## Application for a non-material amendment following a grant of planning permission. Town and Country Planning Act 1990

FIRST FLOOR EXTENSION TO THE SIDE

First Floor Plan  
As Proposed

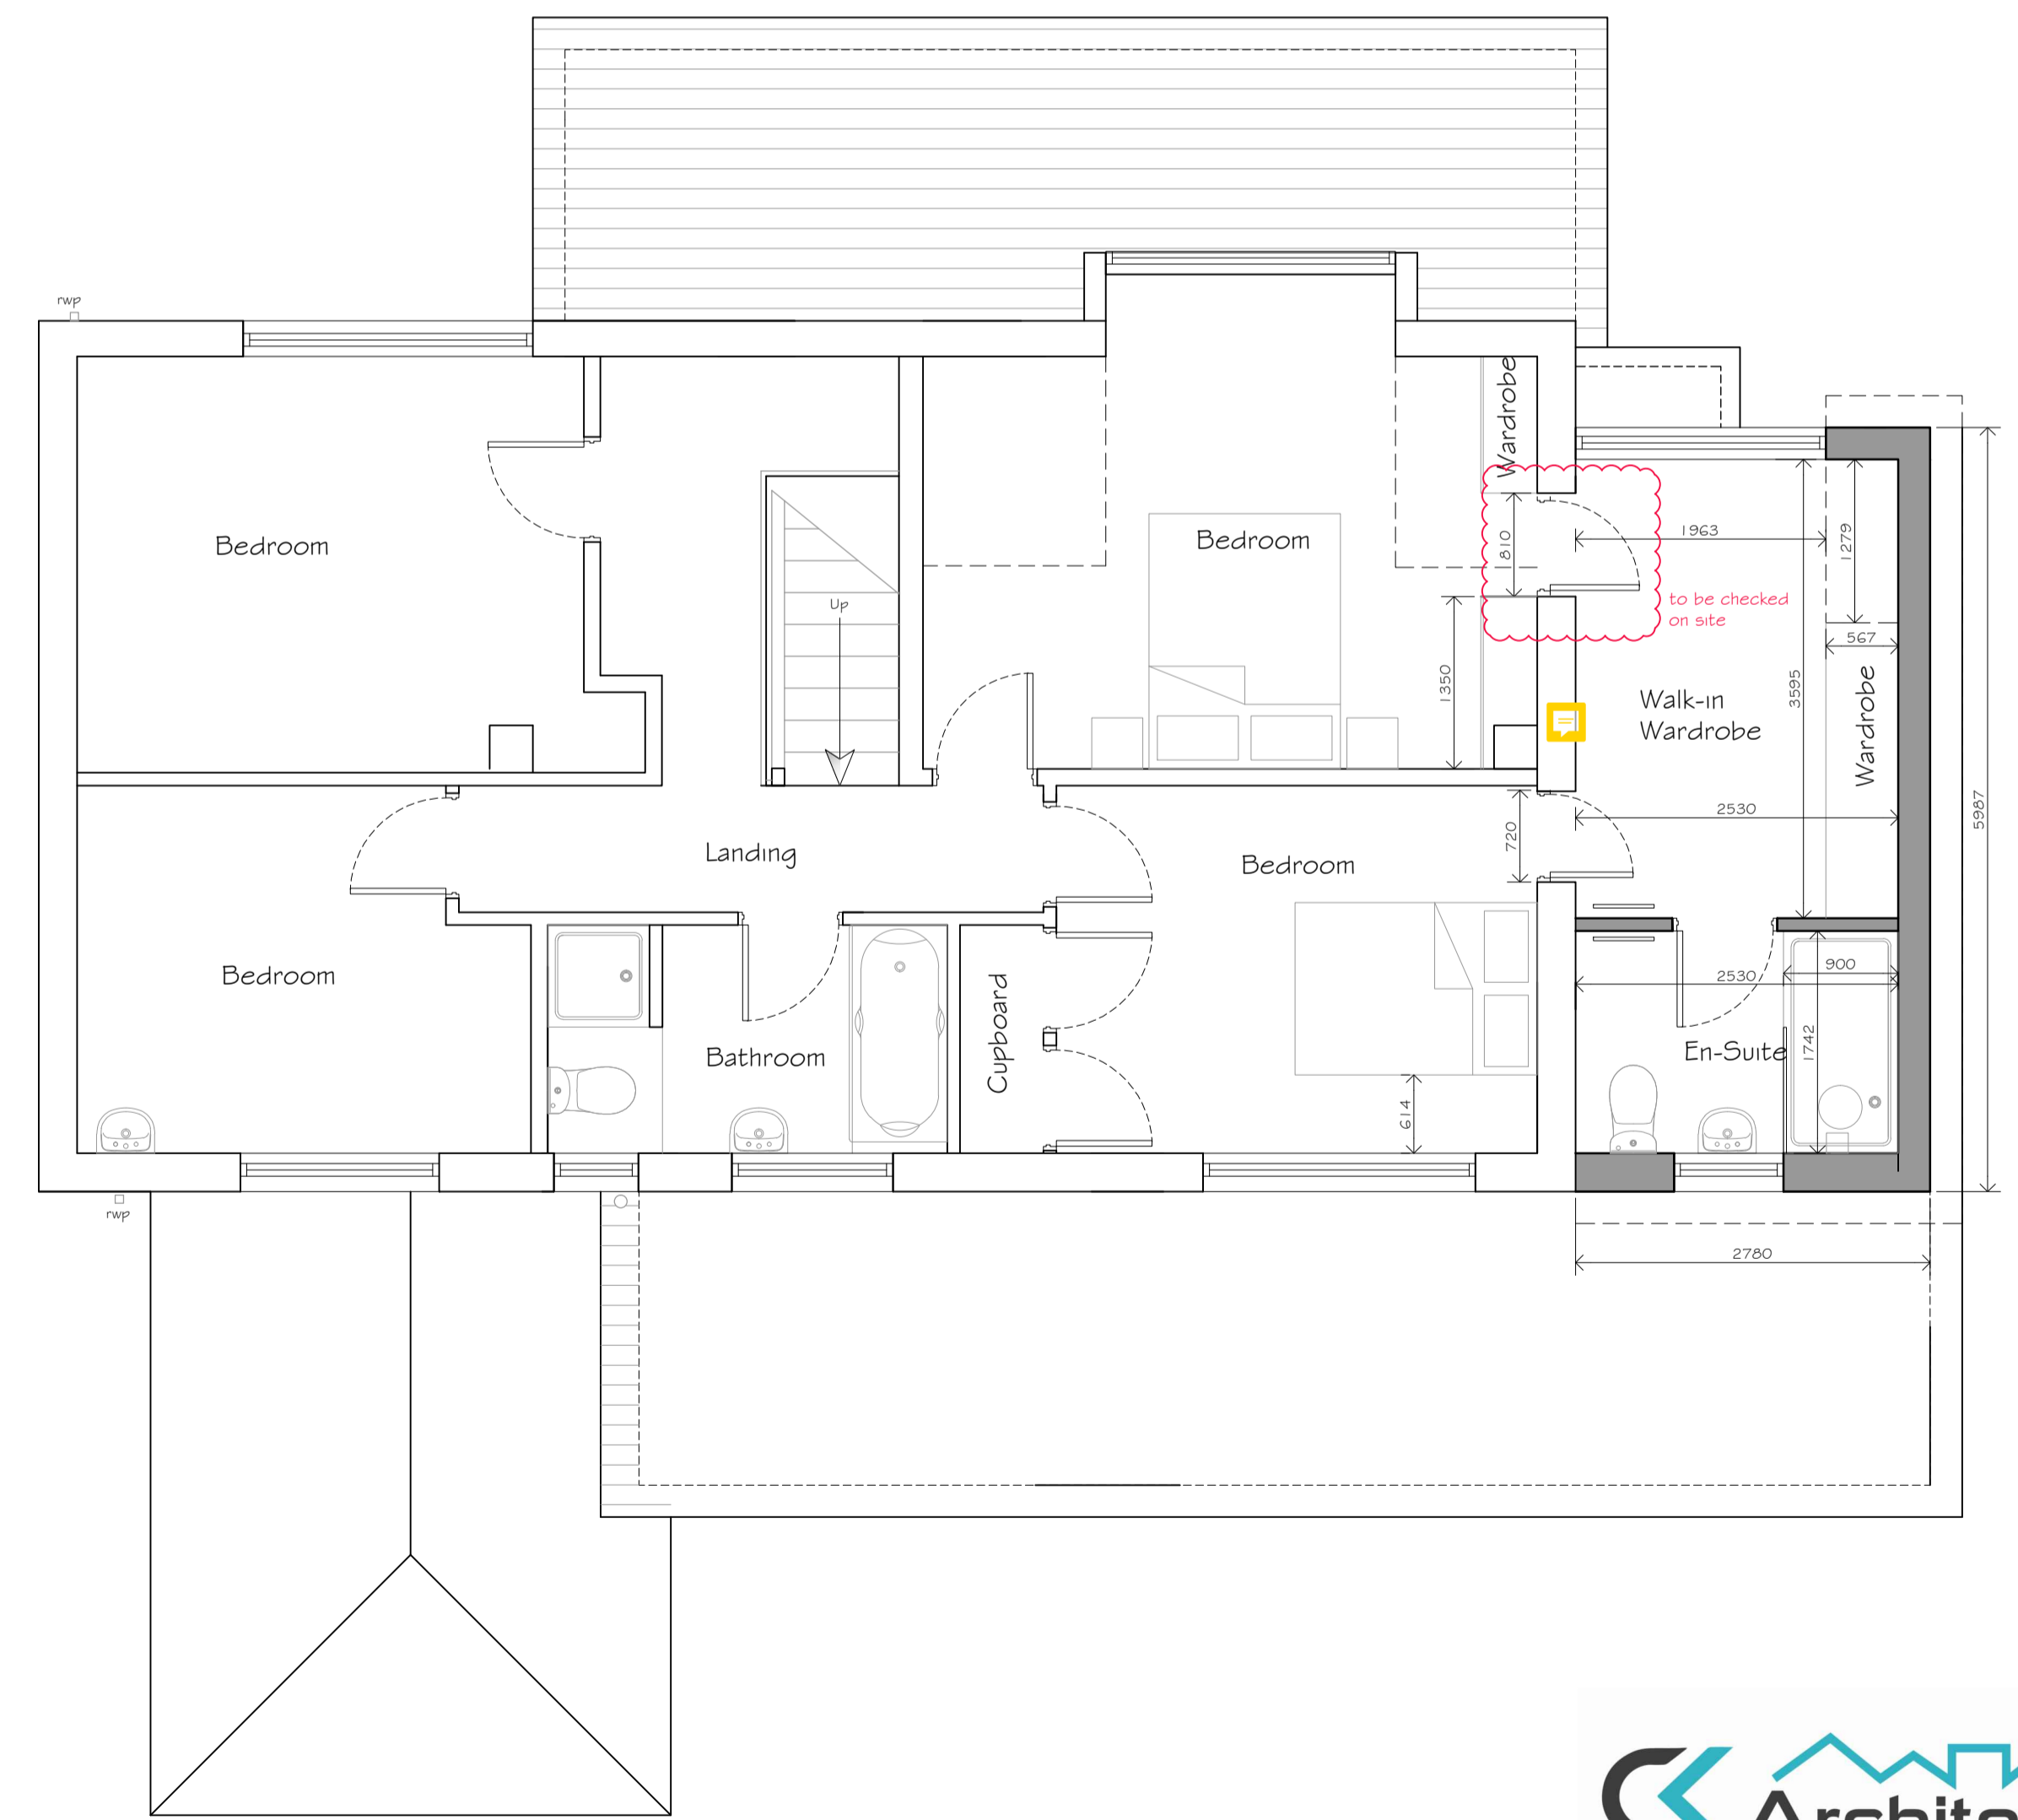
The property has 2 chimneys; the one to the right (west) is functional & the one to the left is not functional (no fire place below this). On commencing building work it has become apparent that the chimney comes in the way of creating the door/lintel between the extension & the bedroom (front). See comments on plan. As the chimney is non-functional we would like to remove it entirely. No alteration/support design is needed for this
